Date: 15 February 2019
Our ref: 267771
Your ref: TR020002

NSIP Reference Name / Code: Manston Airport / TR020002
Natural England's Written Representations in respect of Manston Airport

Written Representation

Figure 3.1
Masterplan - site layout

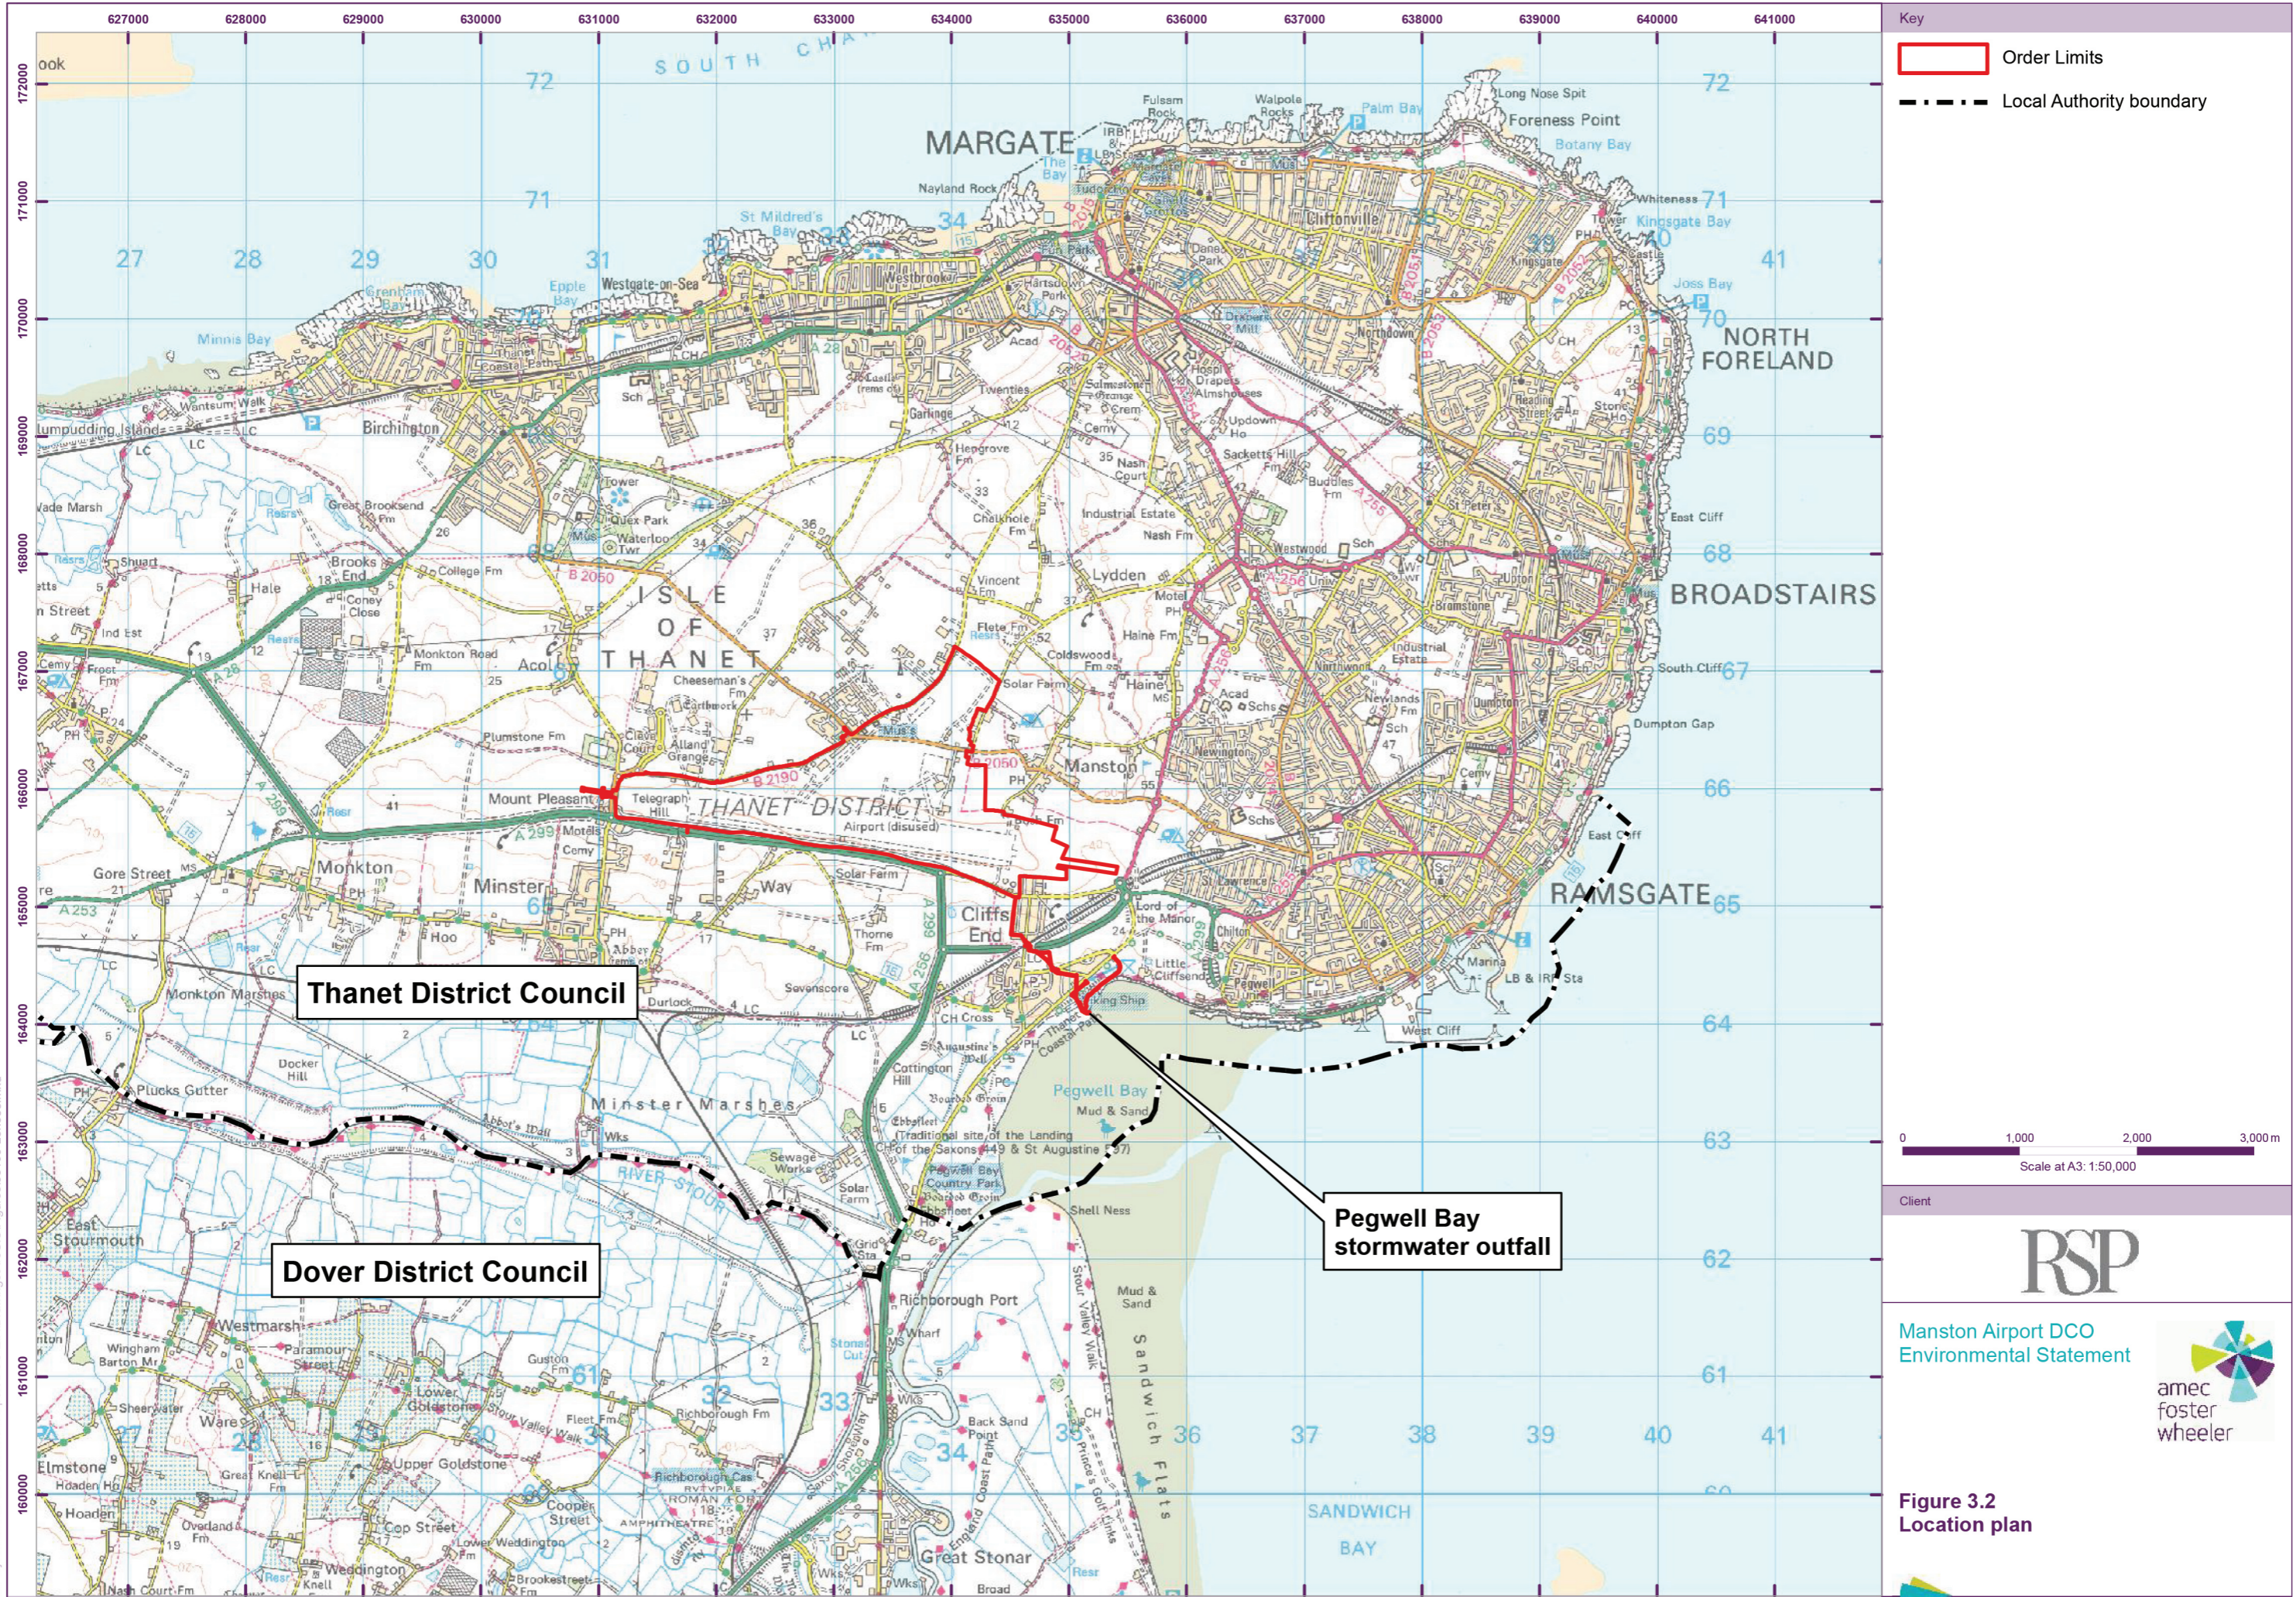
3.2.2 Surveys for the application found a peak count of 530 golden plovers using a field to the south of the airfield red line boundary, and west of the A299 (figure 3.1 in Appendix 7.5 [APP-045]). Use of the same field by a peak of 402 birds was recorded by Henderson and Sutherland², also in November 2016 (figure 4.4 in the Ecological Desk Study Report [APP-045] erroneously records this count as being from within the airfield red line boundary). Paragraph 4.2.4.4 of the RIAA [REP1-007] states that at the end of November 2016 the field was cultivated and became unsuitable for golden plovers.
